TOWN AND COUNTRY PLANNING ACT 1990

FULL

Reference:	H16-0799-26	Date of Decision:	14th October 2026
Applicant:	Mr Barrett 5 Roslyn Court Milton Keynes Bucks MK15 9LA		
Location:	3 Green Lane Spalding		
Description:	Change of use from C4 House in Multiple Occupation to a Sui Generis large House in Multiple Occupation for up to 7-persons

Drawing:
Proposed Floor Plans

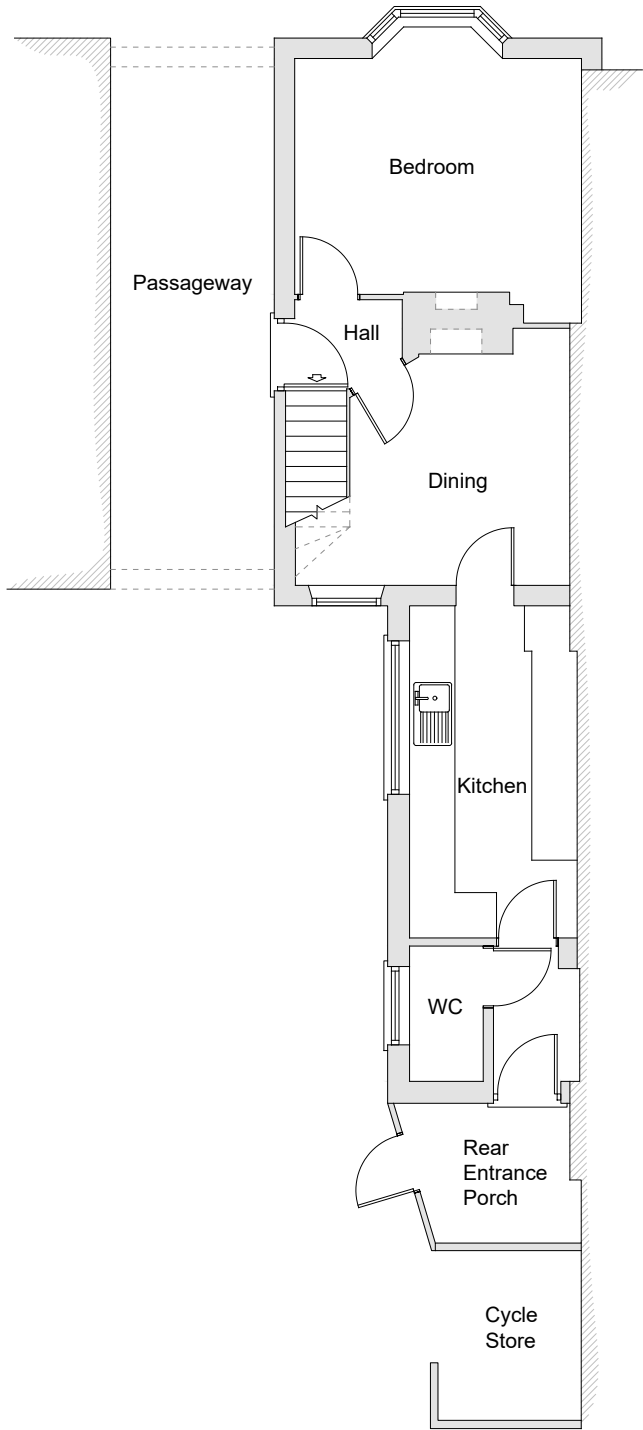
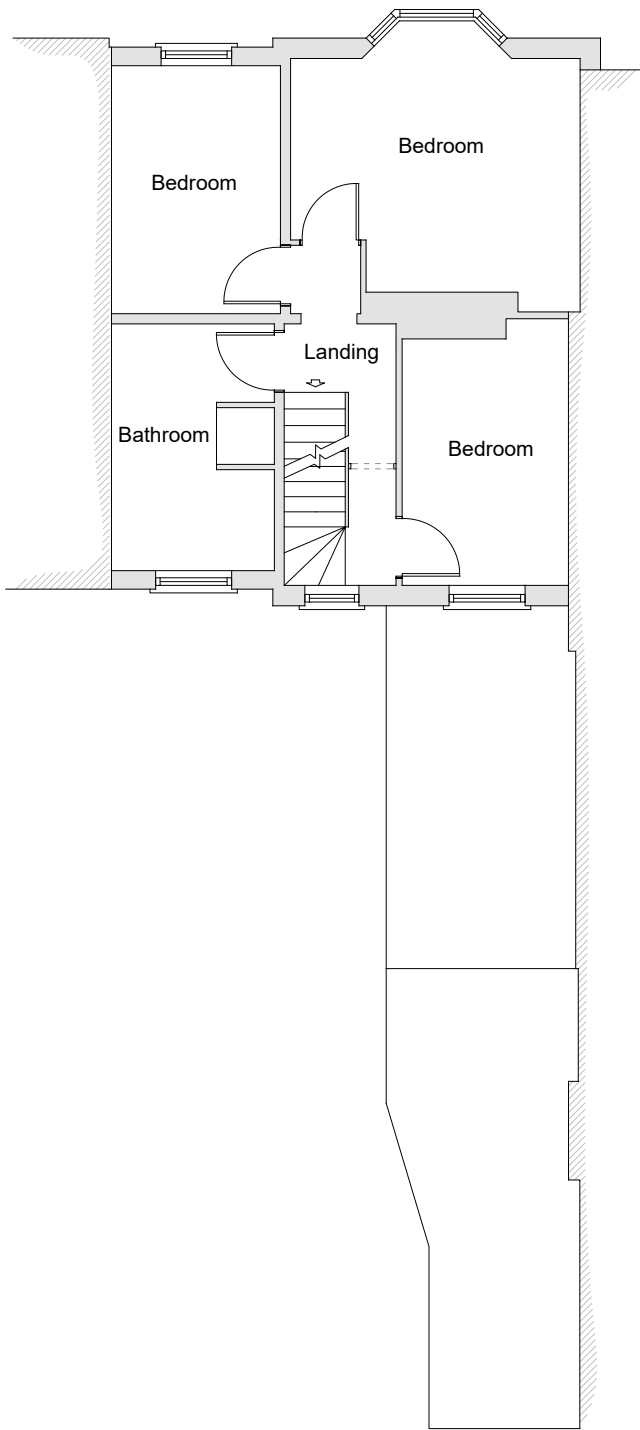
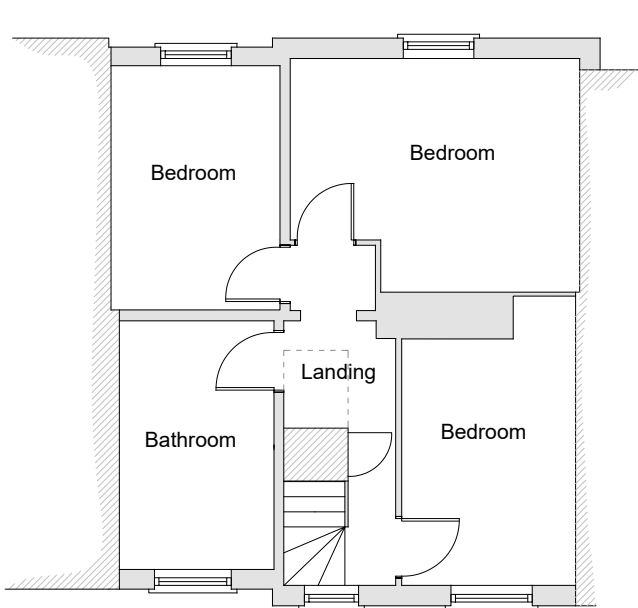
- 1 The property is considered to be of an inadequate size to accommodate the number of occupants to be served by the HMO. Three of the proposed bedrooms, and the property as a whole, would fail to conform to the Nationally Described Space Standards, while there is only minimal communal space, internally and externally, serving the property. This insufficient amenity space would detrimentally impact the standard of living of the potential occupiers. This directly contradicts criteria 7 and 8 of Policy 21 of the South East Lincolnshire Local Plan, 2019 which requires sufficient amenity space for HMOs.
